From: [Michael McGinnis](#)
Sent: Monday, February 15, 2021 5:13 PM
To: JohnGreen@elpasoco.com
Cc: [Susan McGinnis](#)
Subject: Red Rock Acres planned subdivision
Importance: High

As a resident on Rockbrook Road (18815 Rockbrook Road) which adjoins the planned Red Rock Acres subdivision, I have a few comments and questions regarding the new subdivision:

Exhibit 3 - Draft Preliminary Plan

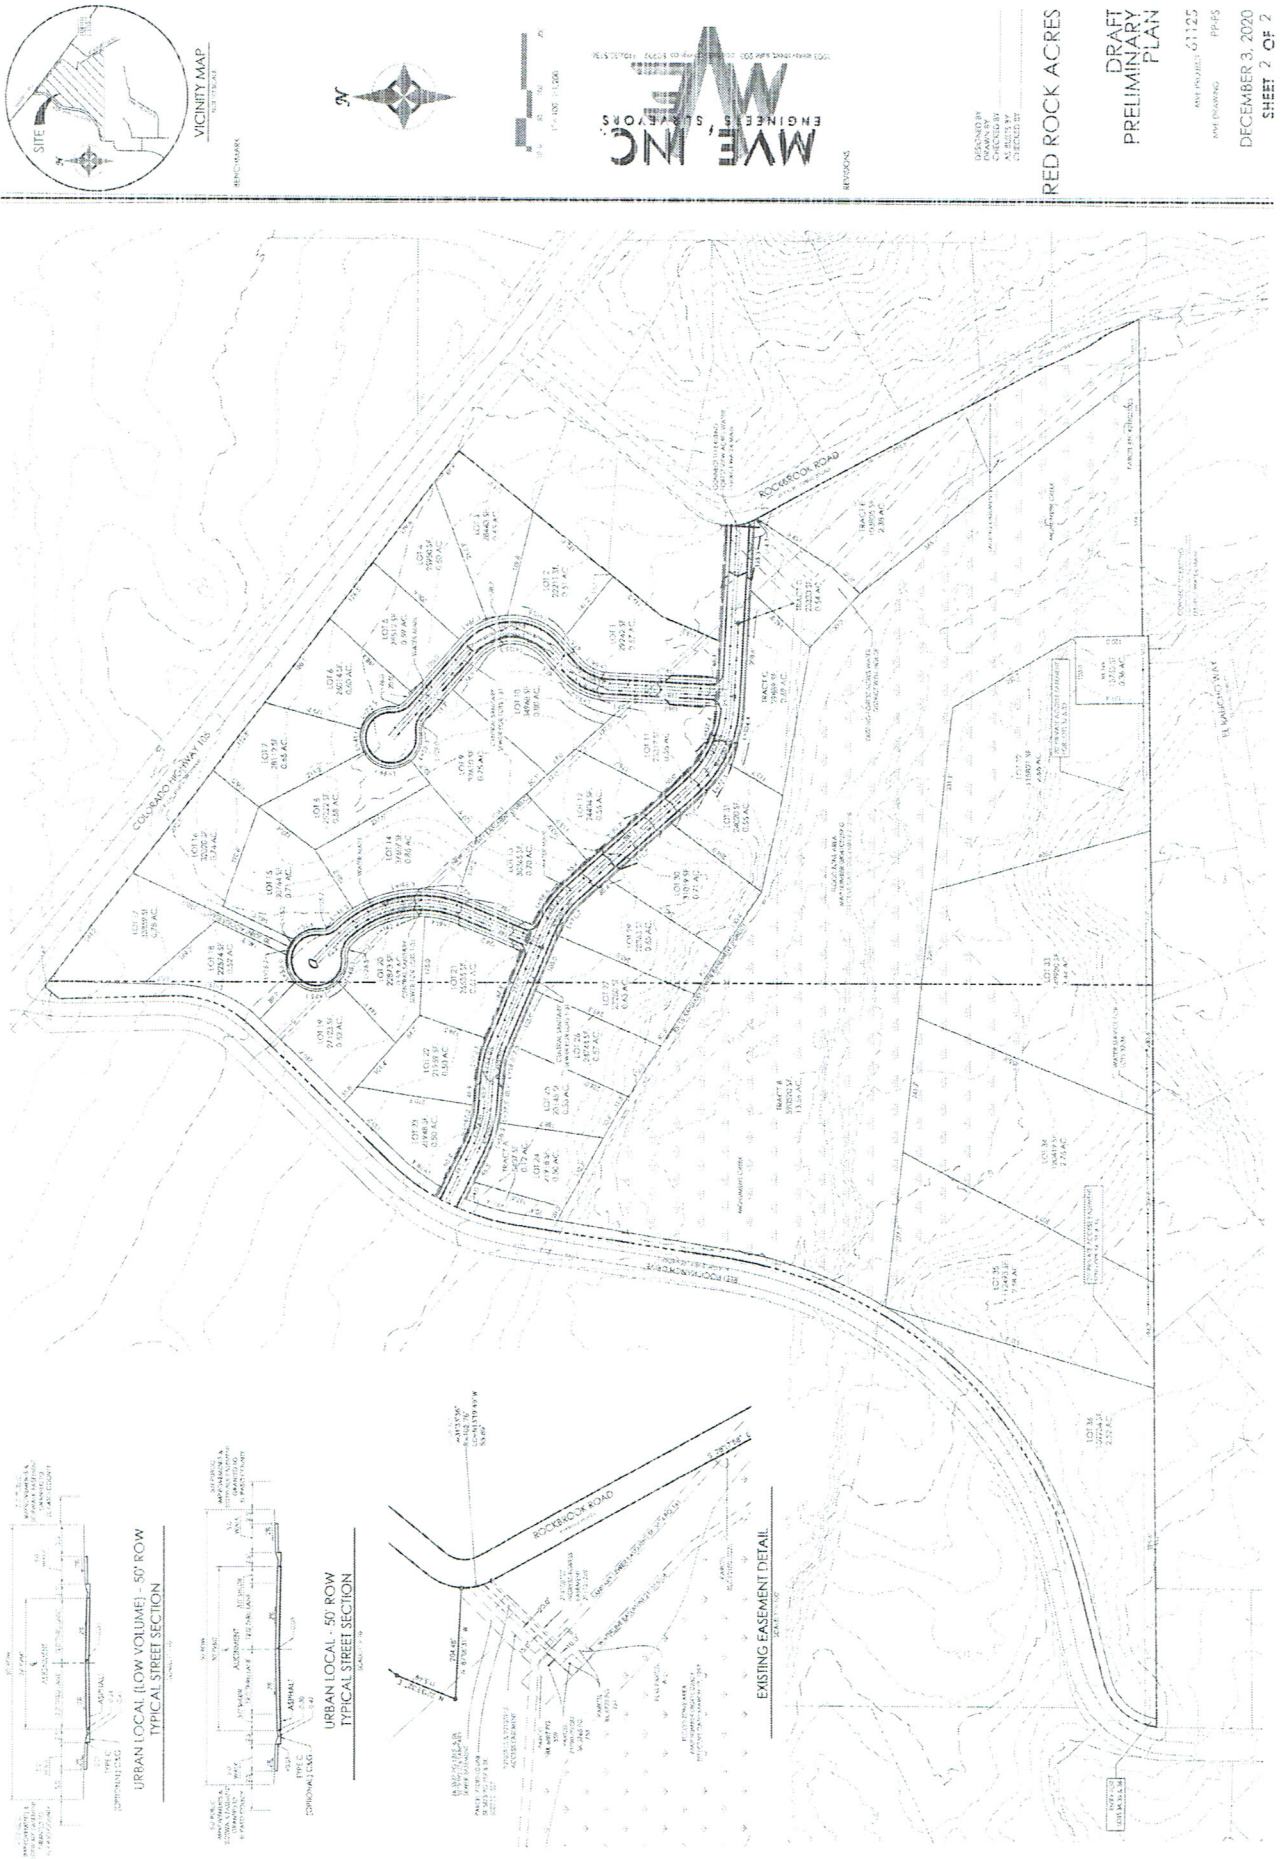
- What are the planned improvements for Tracts B, C, D and E??
 - These tracts are along the flood plain and are habitat for wildlife.
 - As a condition for development, these tracts should **not have any improvements in any way! These tracts should remain undisturbed!**

- What is the plan for the driveway along Lot 36 where it intersects Red Rock Ranch Drive?
 - The intersection of the "Lot 36 access easement" at Red Rock Ranch Drive is not a good location for a driveway in terms of visibility and safety.

- As part of your planning review, please be certain that the developer creates a safe access for the owners of Lots 34, 35, and 36.
- Is Forest View Acres Water District the source for water for this subdivision?
